Subject: RE: Discharge of Condition 5 BE/18/17/PL - New Barn Lane, North Bersted

Condition 5 (surface water drainage)

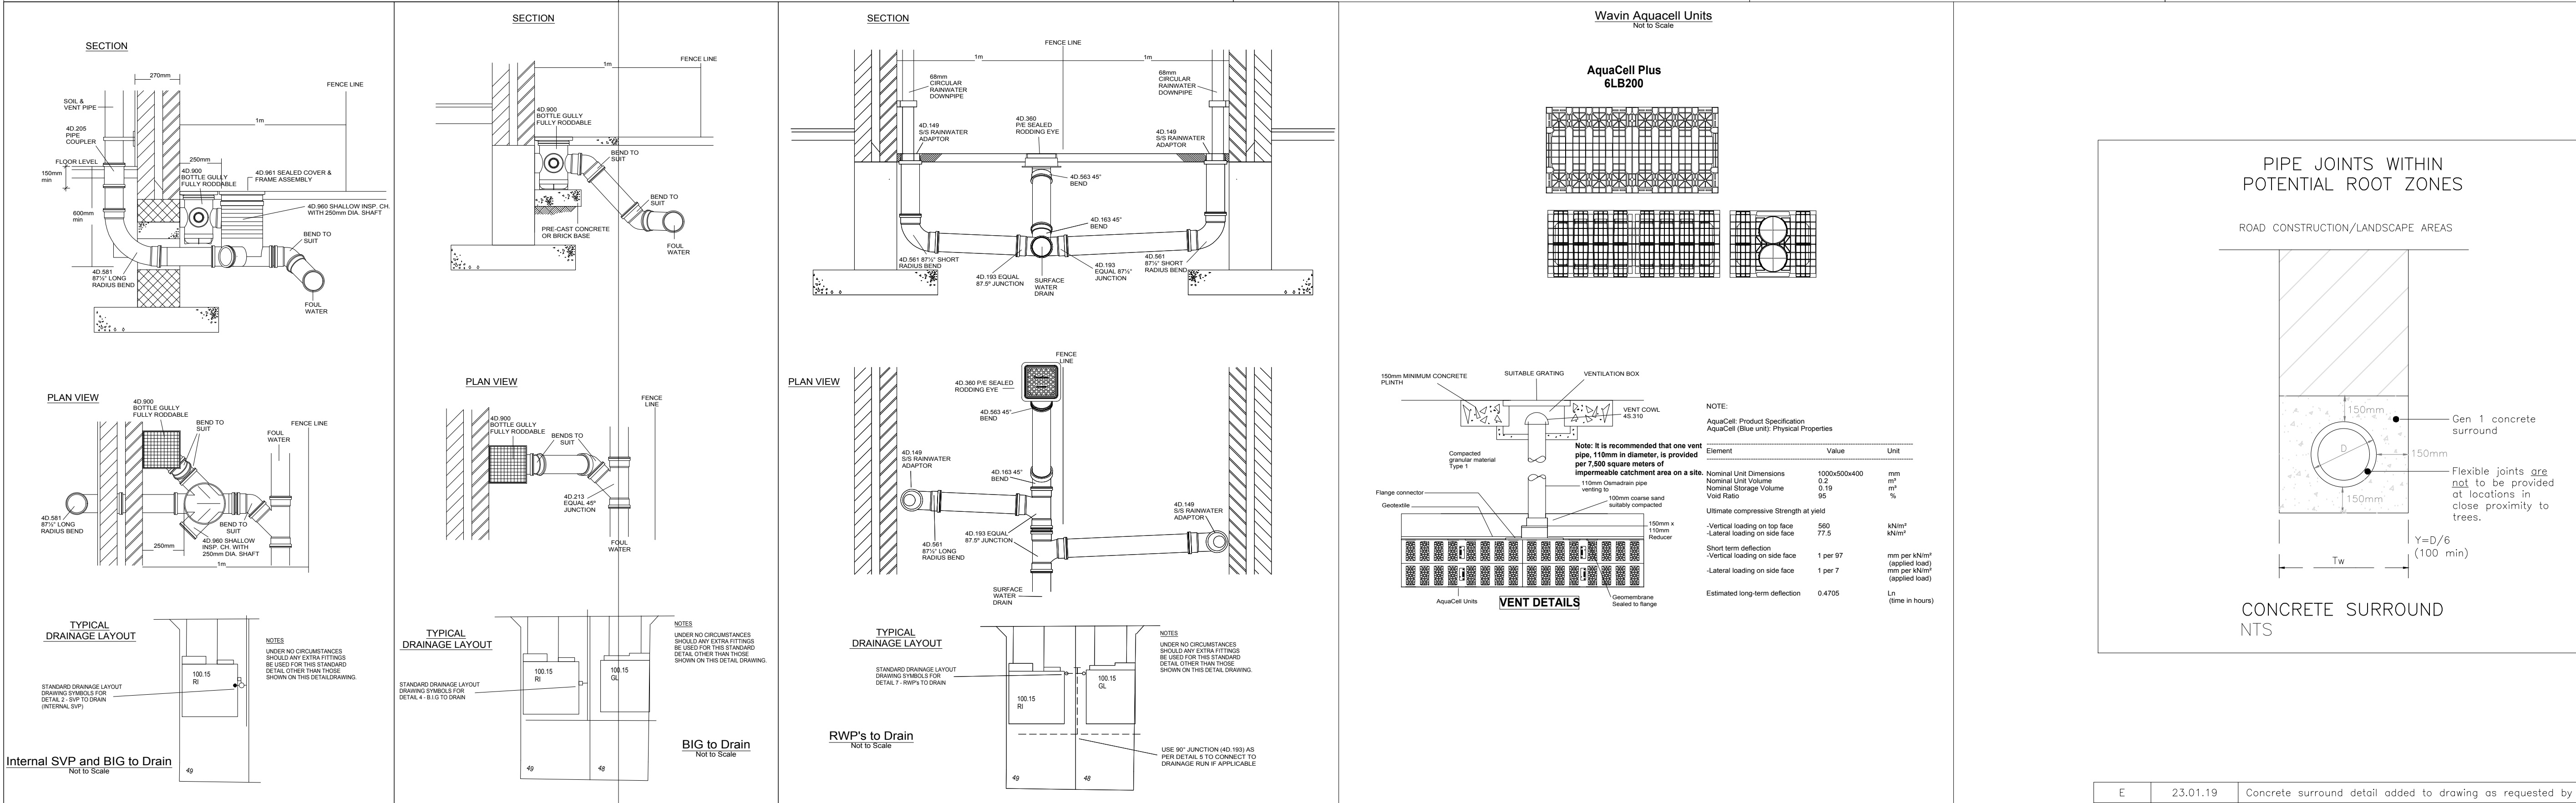
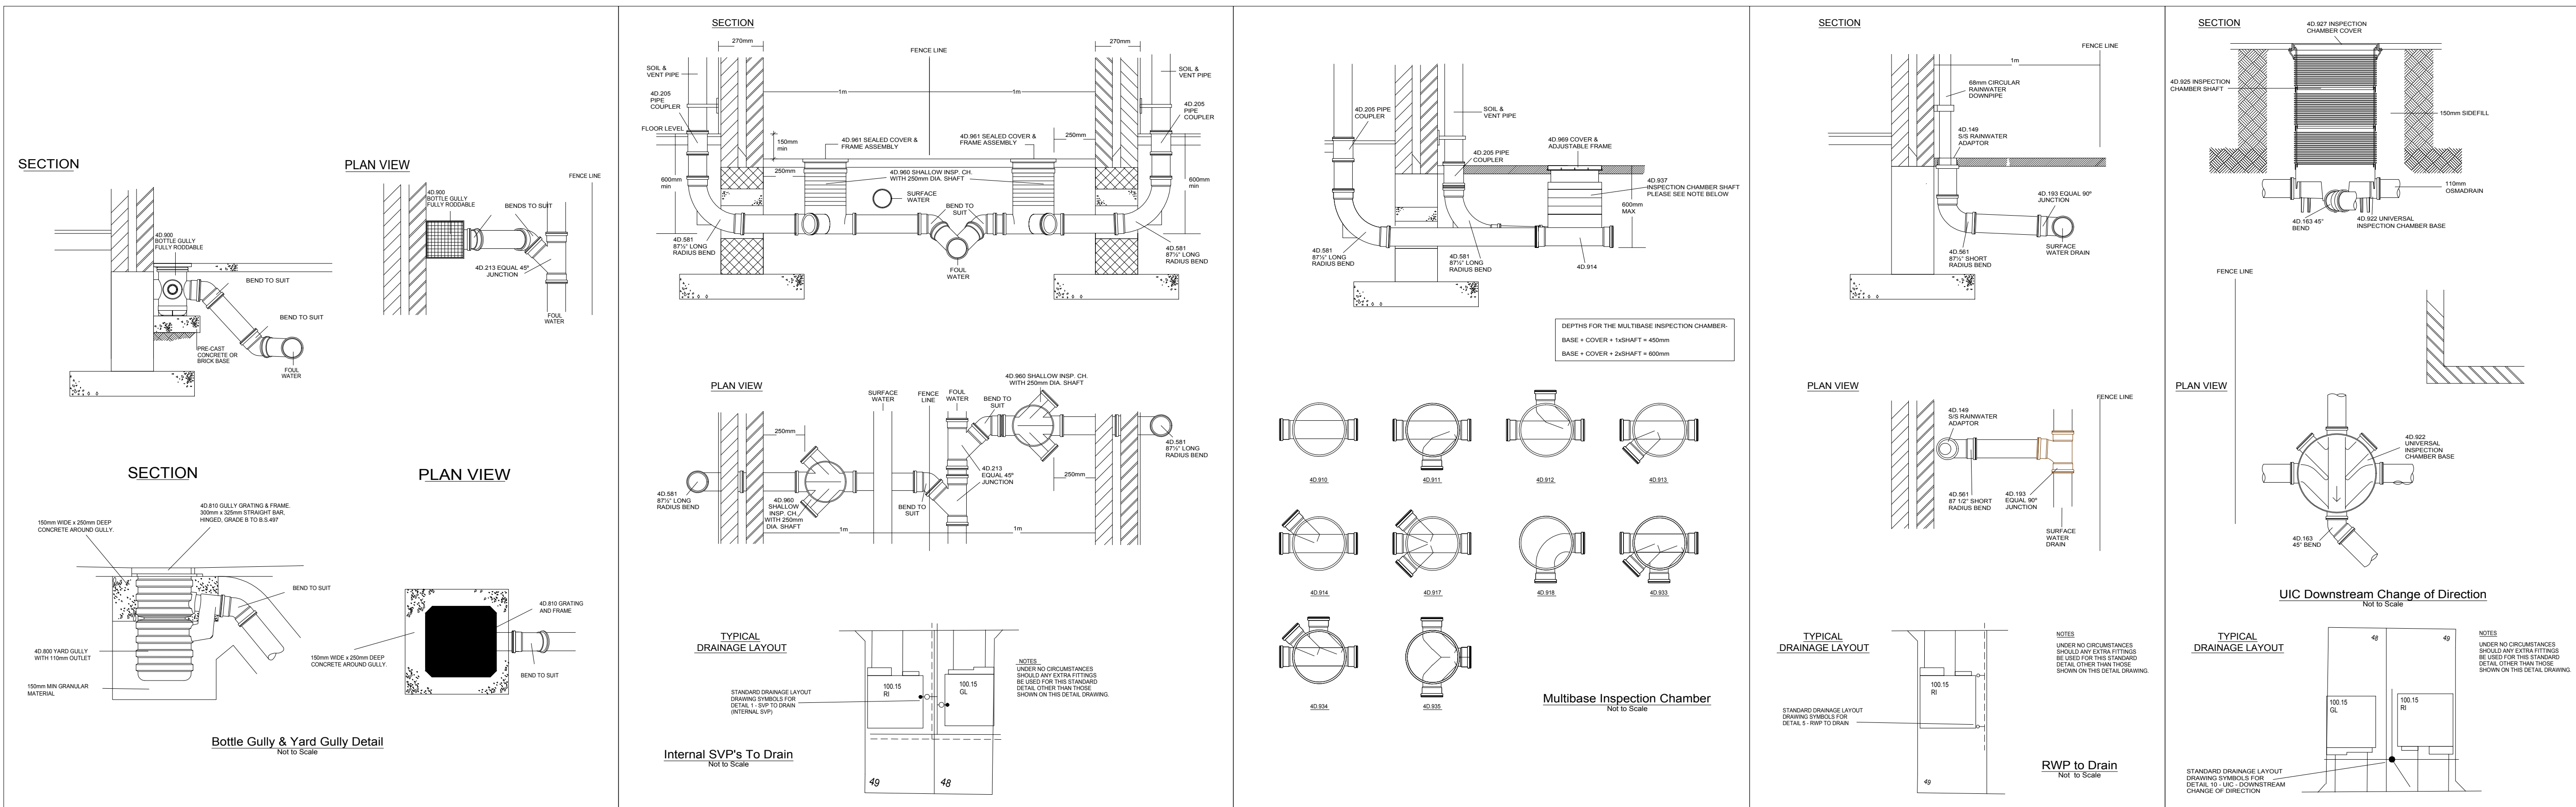
4. 150mm concrete bed and surround will need to be provided at all pipes joints within potential root zones.

MJA Response—Noted, concrete surround detail added to Drawing LMS232-1022 revision E; Okay.

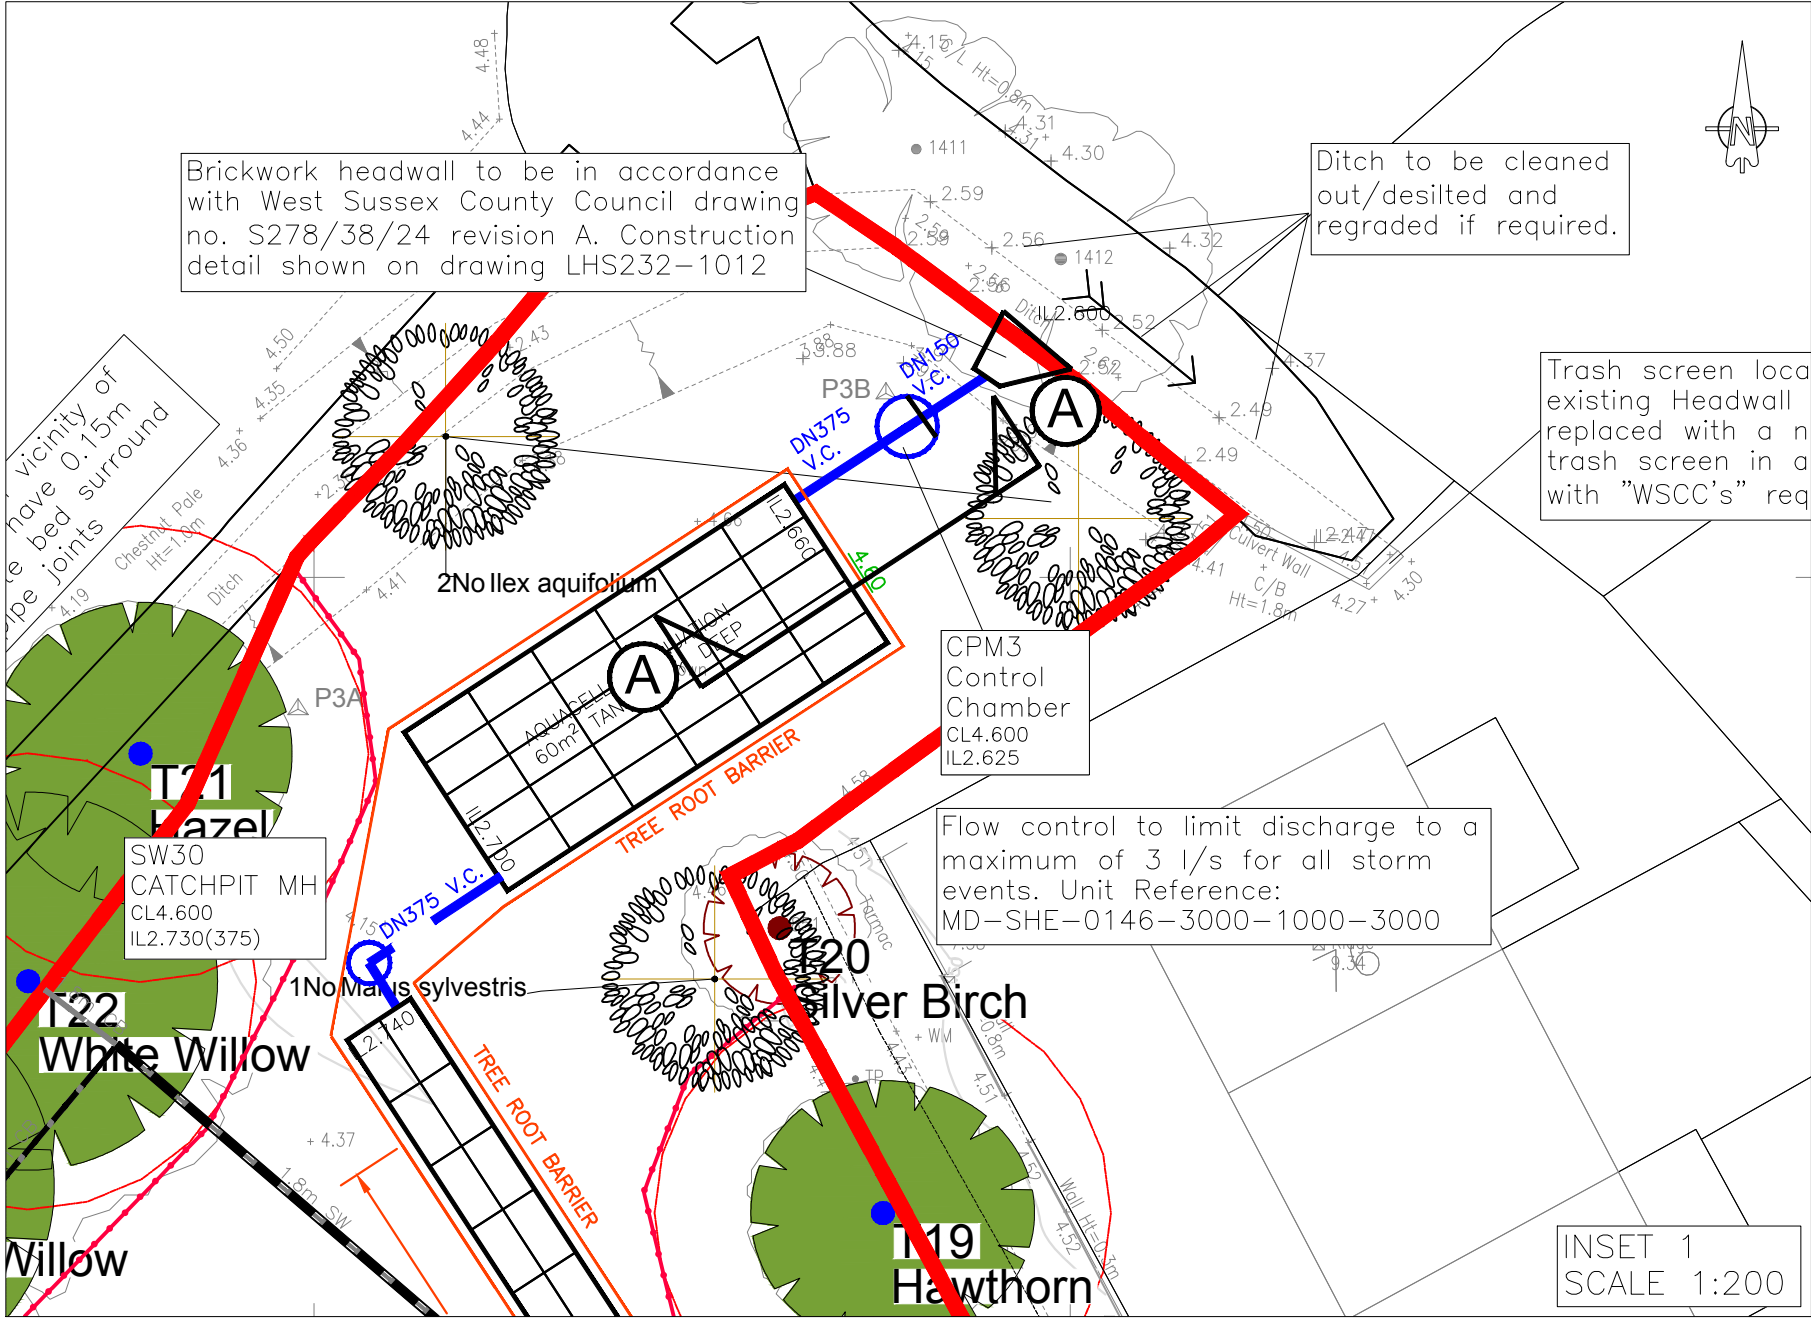
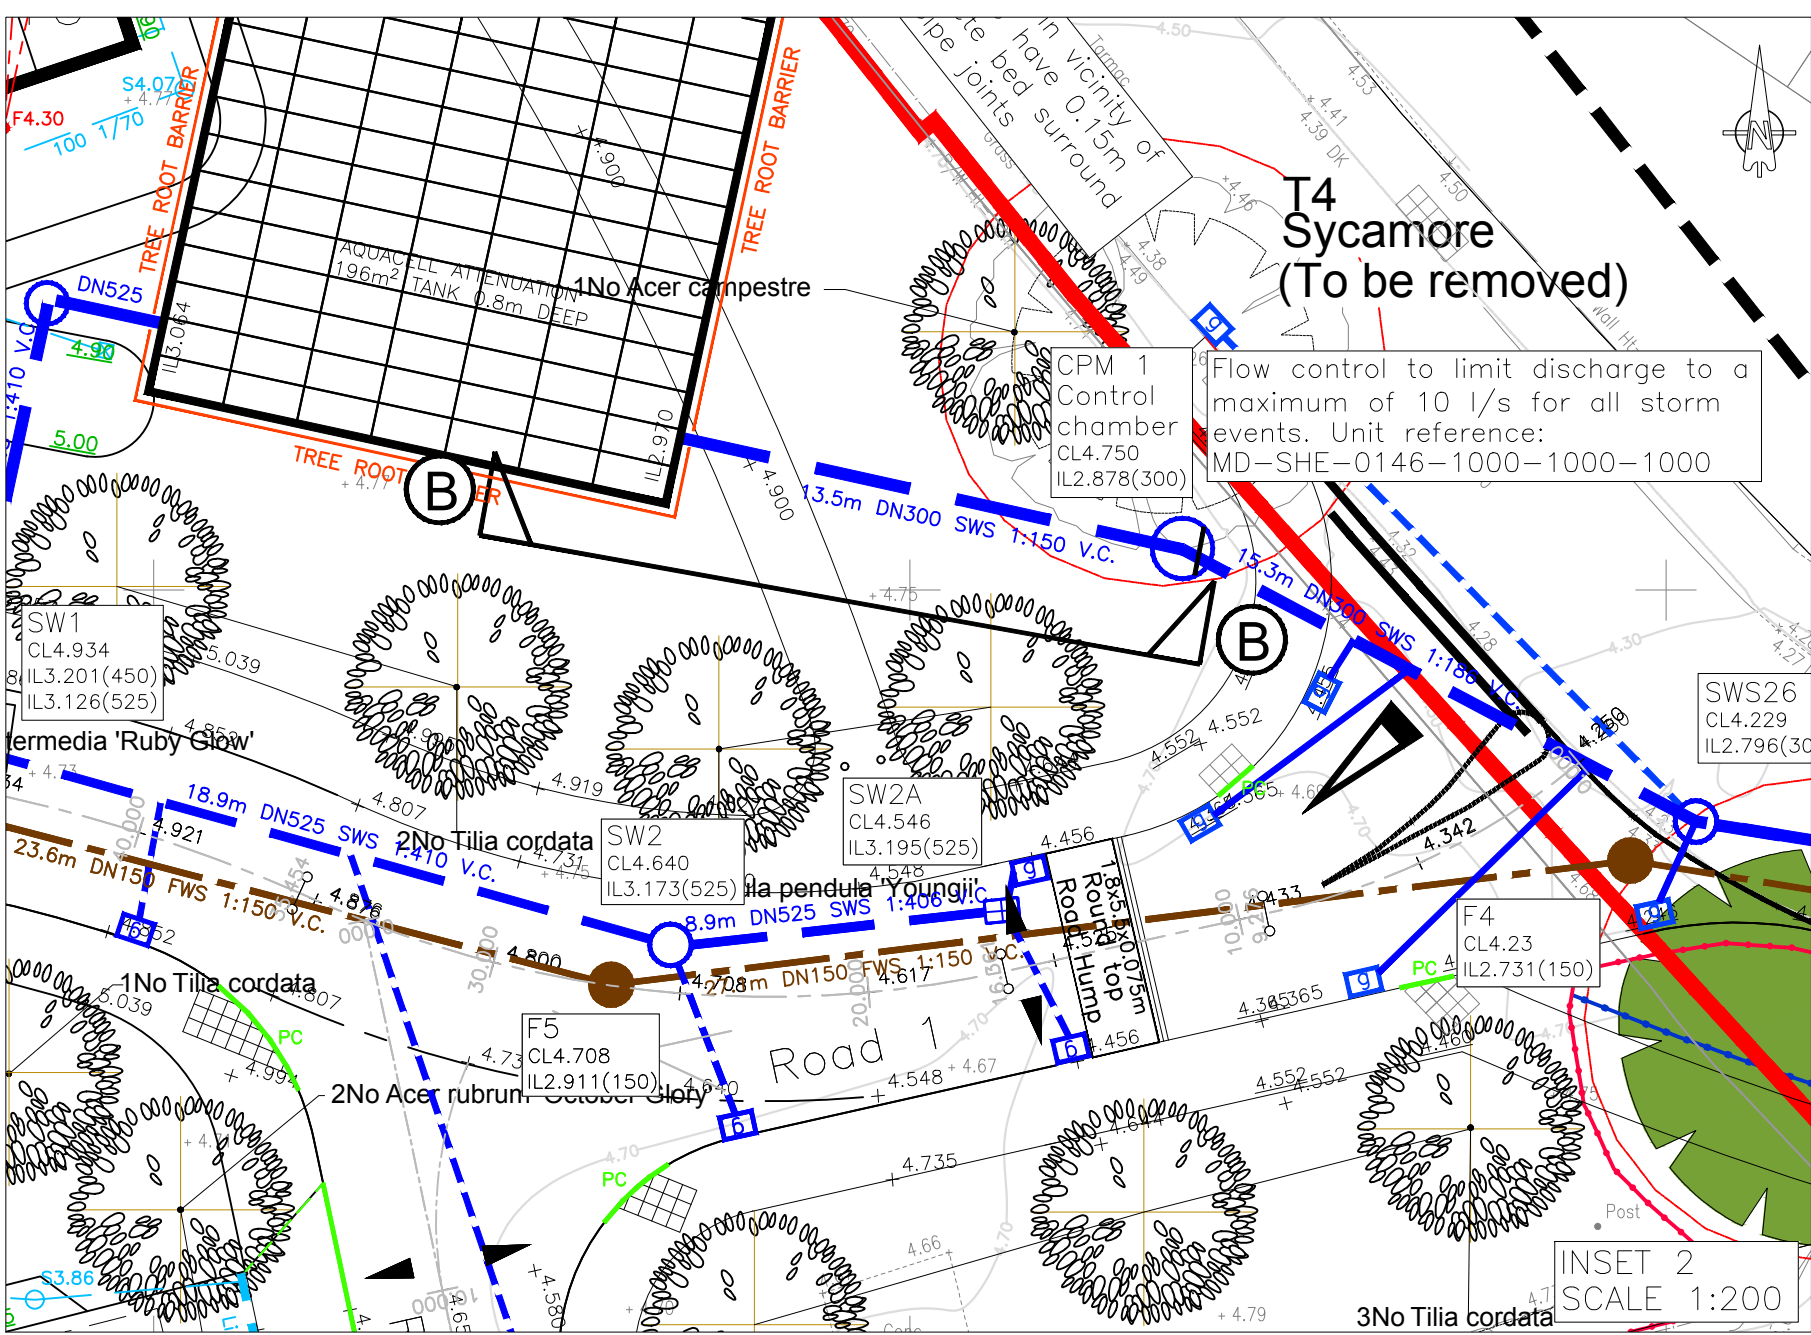
5. Please supply uplift calculations for the attenuation tanks with submission. Uplift calculations for the tanks will be within the dropbox link, although as noted by Laura these have been previously issued but we are happy to issue them again

However, the depth of groundwater displaced in your calculations is incorrect. You are displacing 1.7m of groundwater, not 1.4m. This means that you do not have sufficient resisting forces. Please revise.
